**Letter of Intent
August 2017**

Project: South Academy Business Center

Applicant/Consultant: ADP Civil
3520 Austin Bluffs Pkwy, Suite 102
Colorado Springs, CO 80918
719-266-5212

Markup Summary

SOUTH ACADEMY BUSINESS CENTER

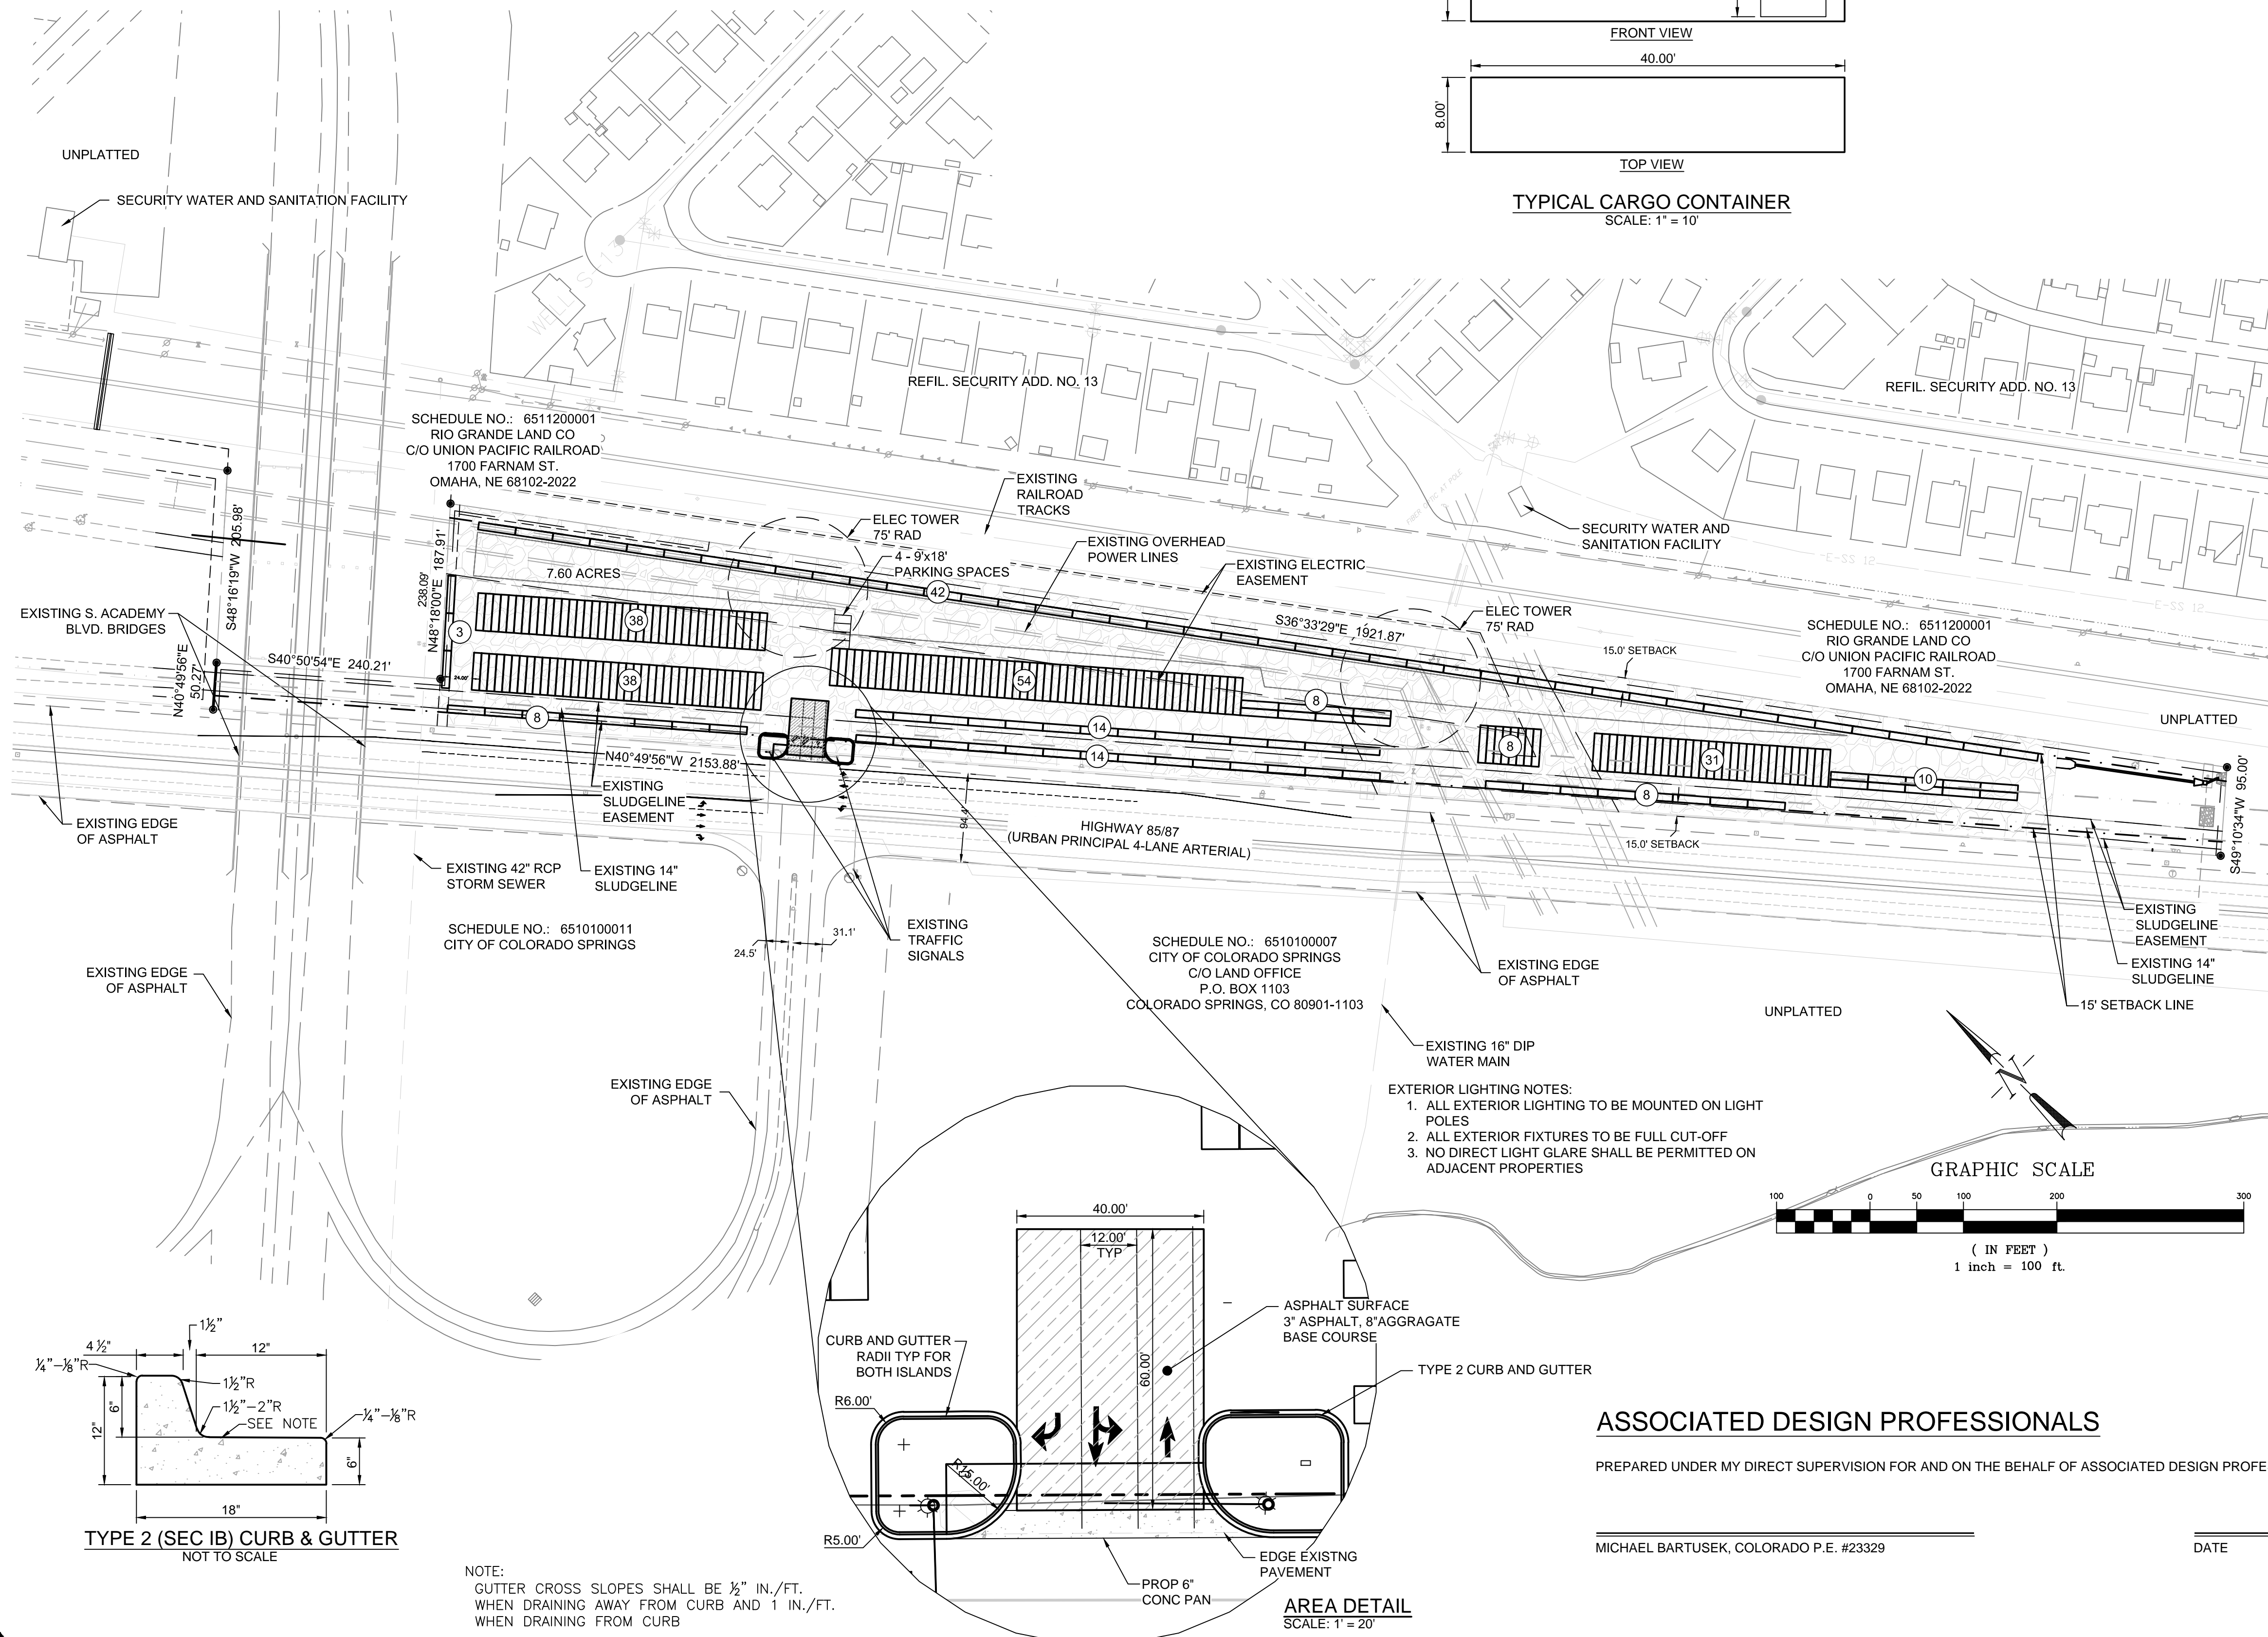
A landscape buffer of 15' along the residential side of the site is required due to use to use compatibility concerns from the Board of County Commissioners.

How many employees? This will effect how many parking spaces are required.

How many units total will there be? This is needed to determine parking.

Setback waivers are administratively applied for up to 20%. Anything further than that would require a Board of Adjustment Hearing.
